CITY OF ALBUQUERQUE

Re: Boca Negra Dam LOMR June 15, 2015
Engineer's Stamp Date –no seal or stamp- (D10D000)

Based upon the information provided in your submittal received 5-11-15, the following comments are to be addressed:

OVERALL LAYOUT PLAN

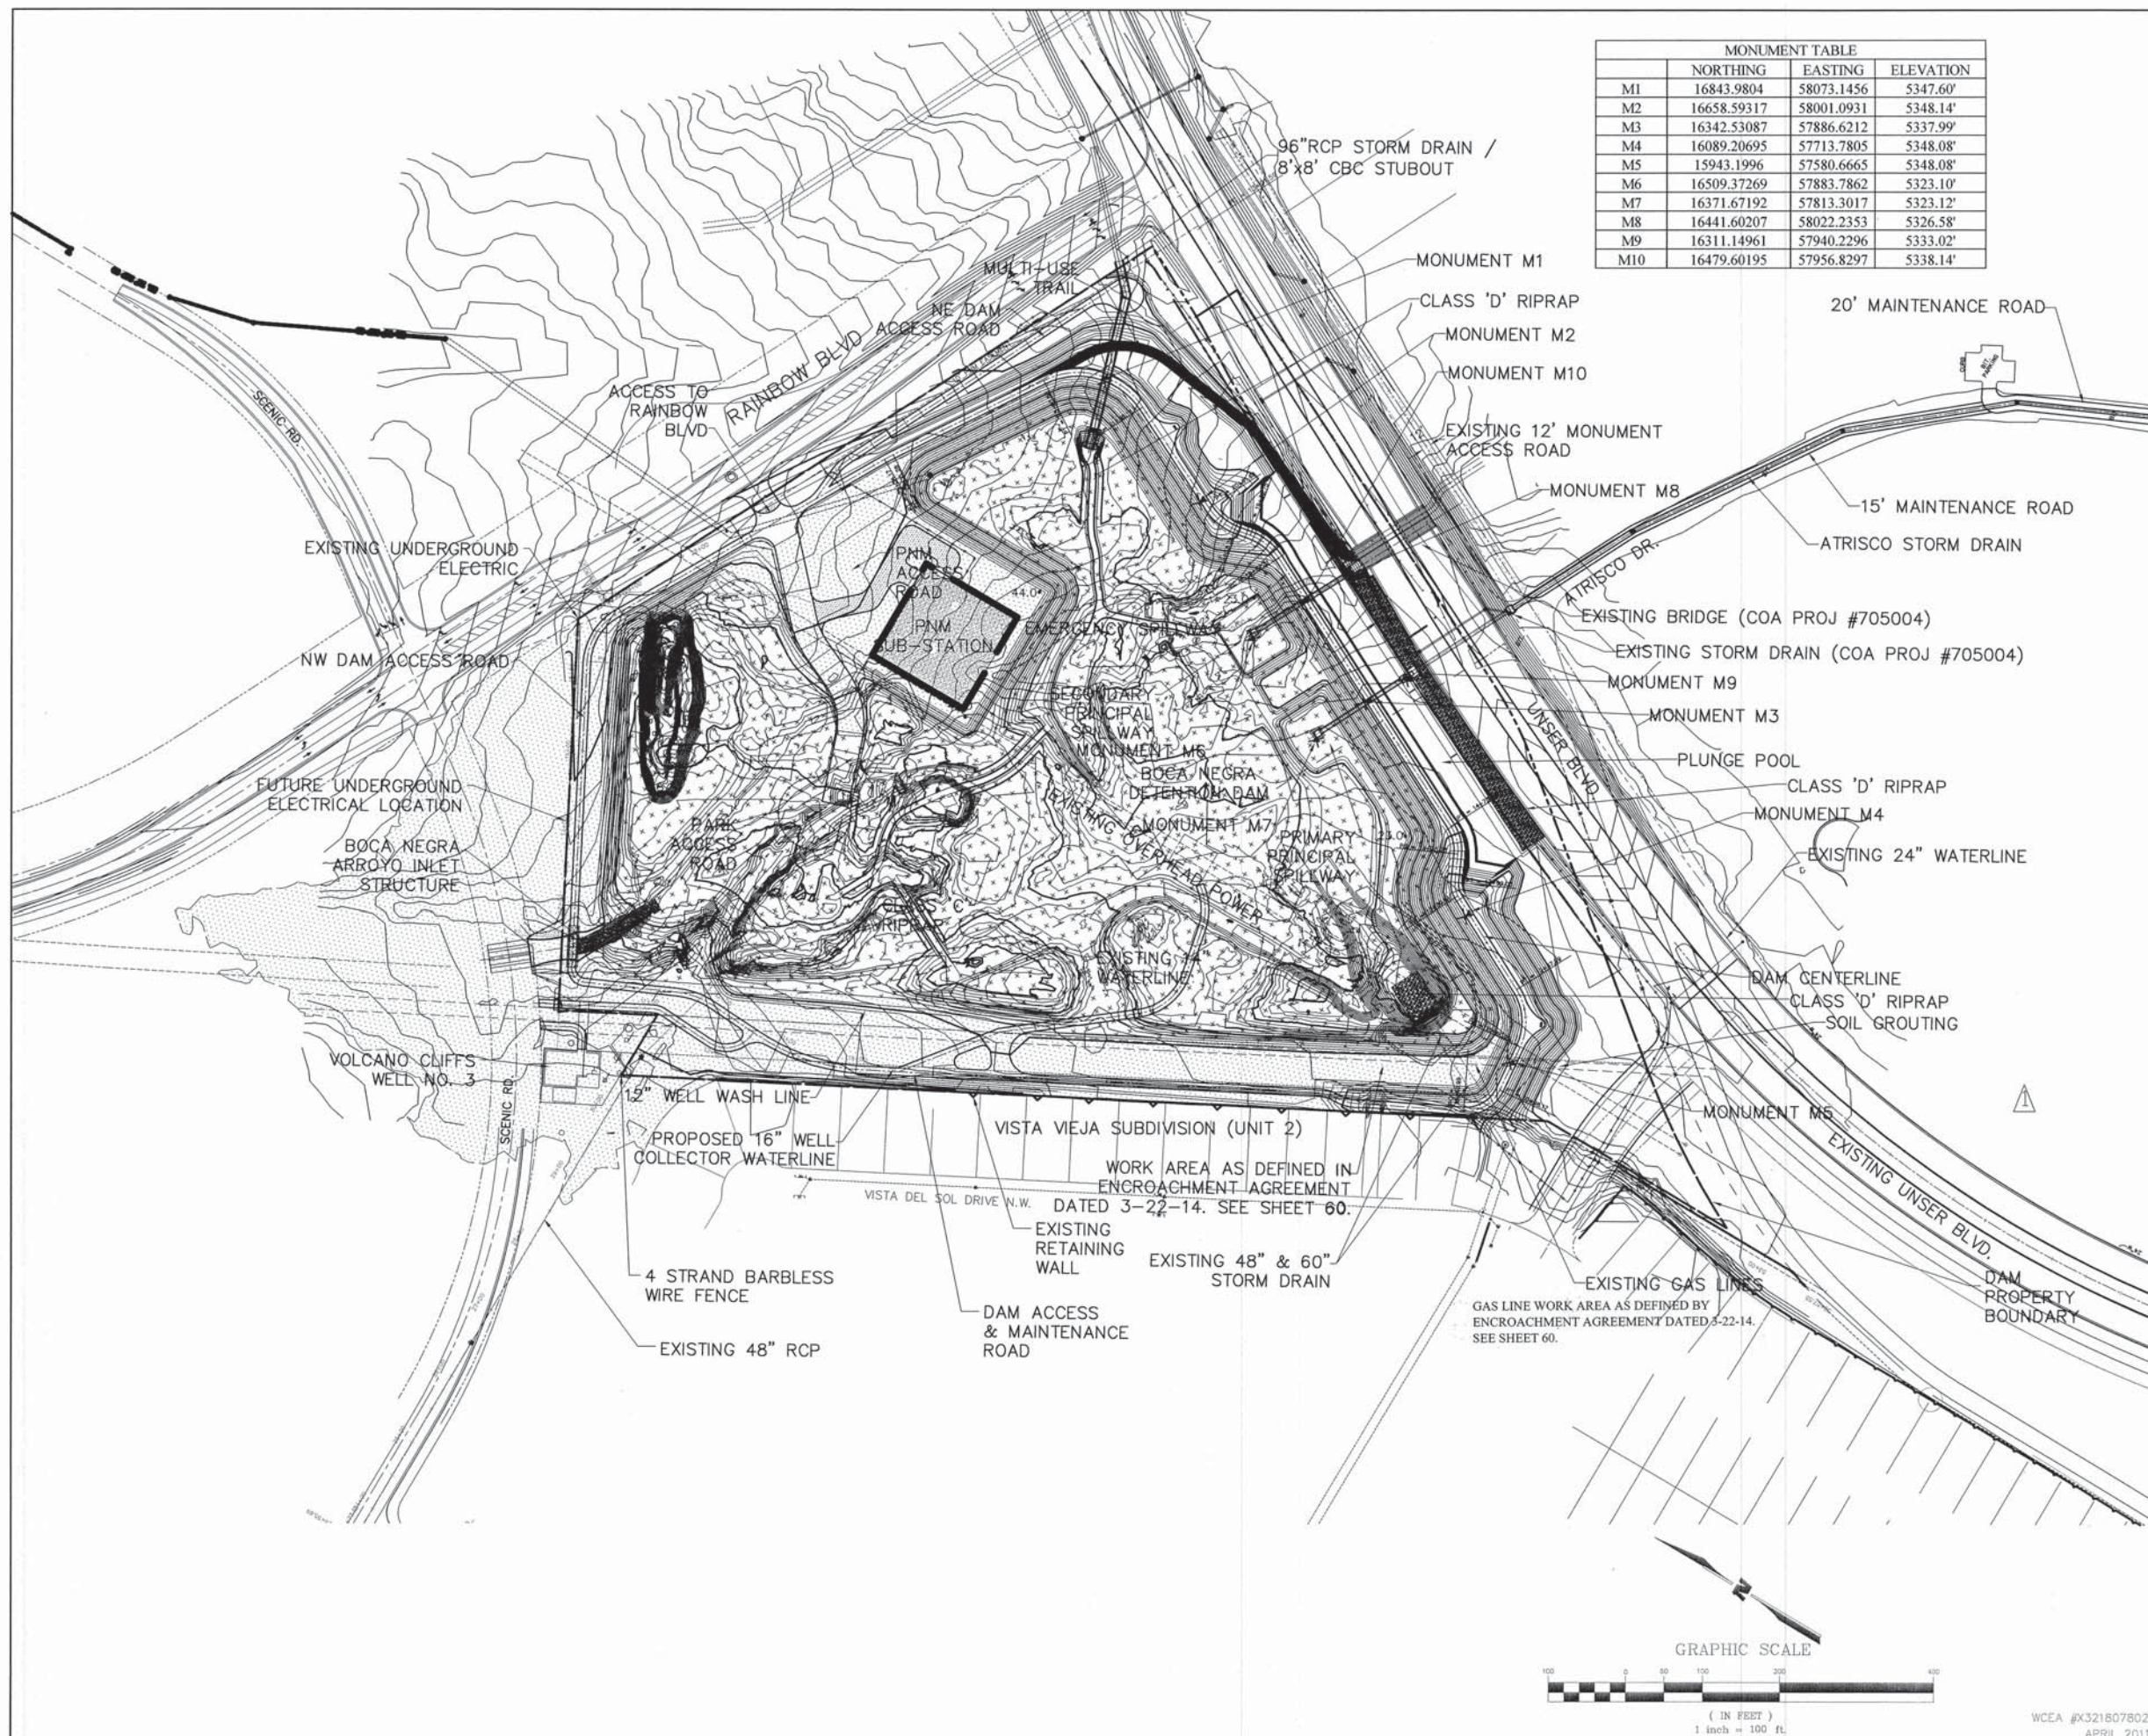
7. Wilson and Company is the Engineer of Record for SAD 227, SAD 228, and the Boca Negra Dam. A revision to the Boca Negra Dam construction plans was made without City approval which reduced the volume of the dam and lowered the elevation of the principal and secondary spillways. Lowering the elevation of the spillways had the effect of increasing flow out of the dam. These three areas all discharge into the channel below the dam. Per the City's Drainage Control Ordinance any activity or change in land use shall not result in downstream capacity being exceeded. Downstream capacity appears to be exceeded in the channel below the dam where two structures have been identified in the revised floodplain. Wilson and Company is to come up with solutions so the flood plain is not increased on developed properties. Possible solutions that may be effective are:

6423 Star Bright Road

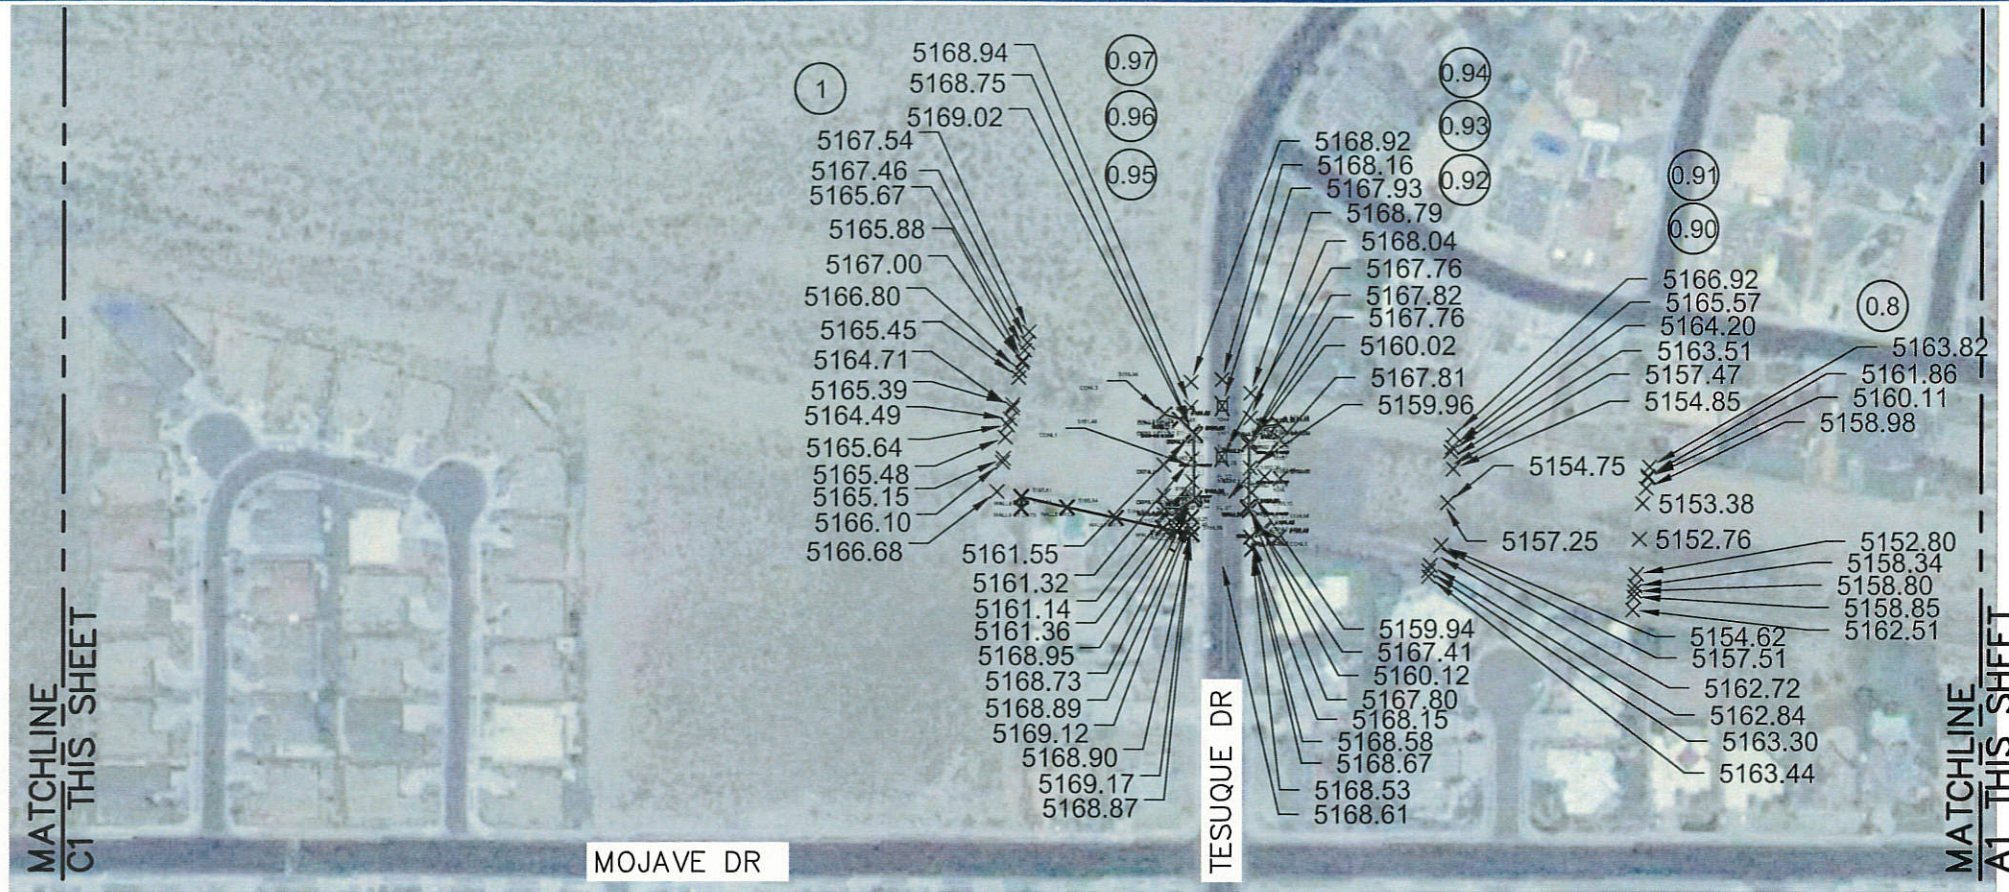
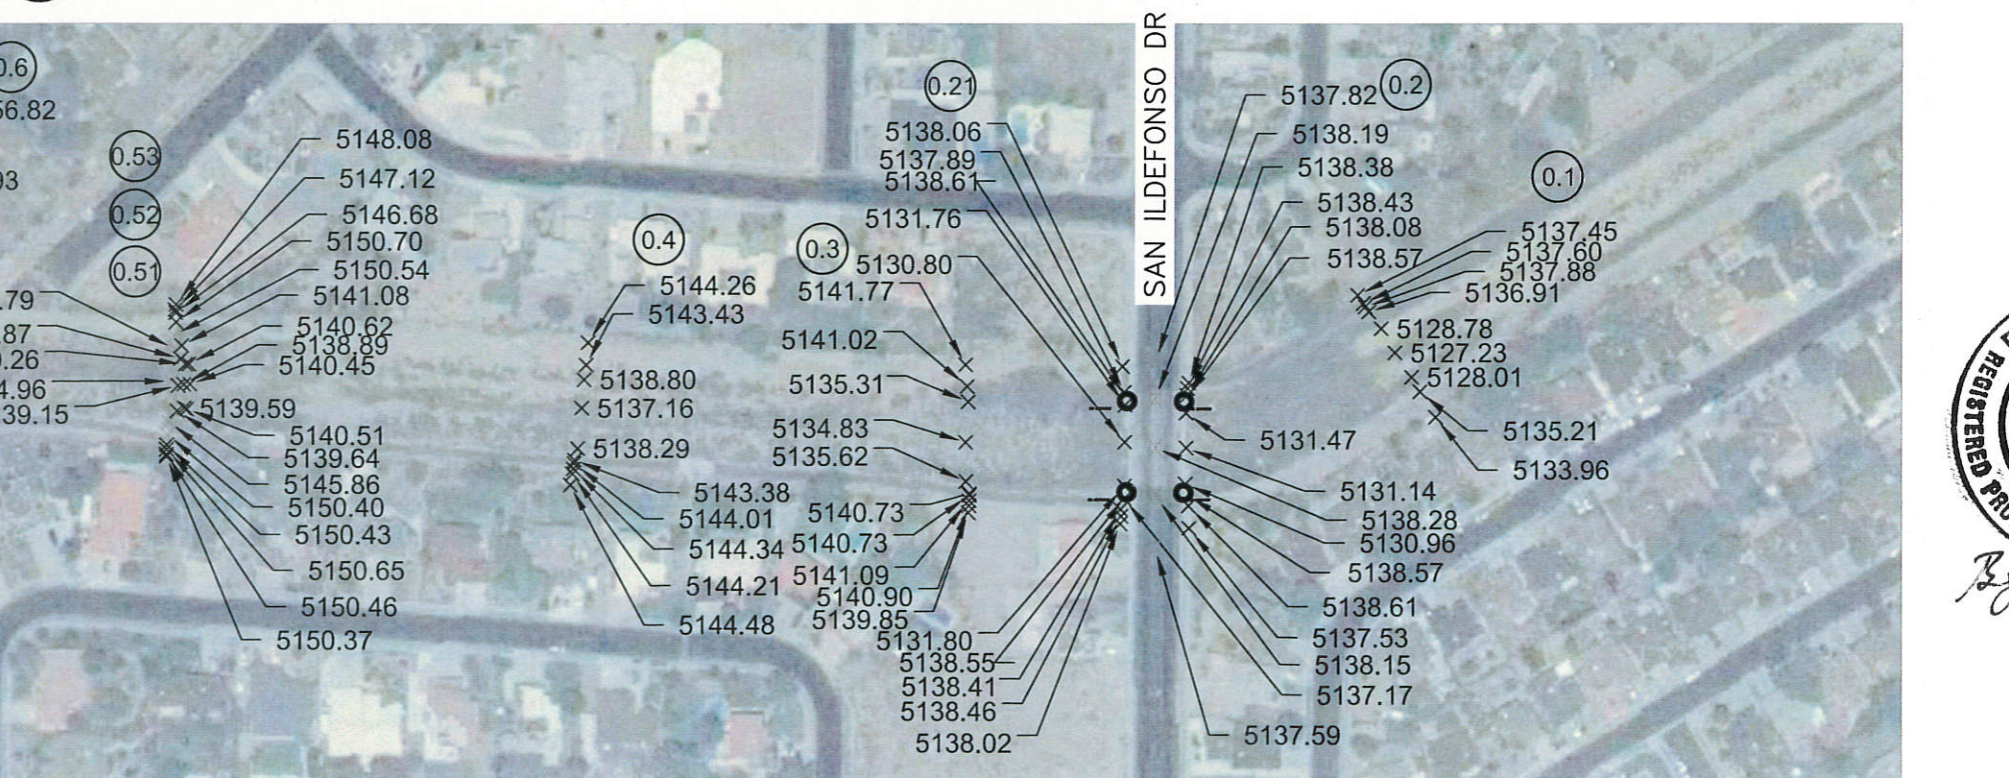
- e. Construct something.
8. It is difficult to tell the extent of the adverse effect on downstream properties, including 6423 Star Bright and 6515 Tesuque drive without the newer aerial imagery. If the impact is great enough, properties owners may be required to purchase flood insurance as a condition of their mortgage (if they have one). Policies could cost \$2000 to \$4000 per year. The impact may also reduce the value of their property.

9. The property at 6423 Star Bright appears a minimum of about 3 feet above the thalweg. There is a sewer manhole about 5 feet north of the northwest corner of the lot. The rim elevation should be on as-built construction plans. The property is higher than the rim elevation. This may help adjust the flood plain in this area.
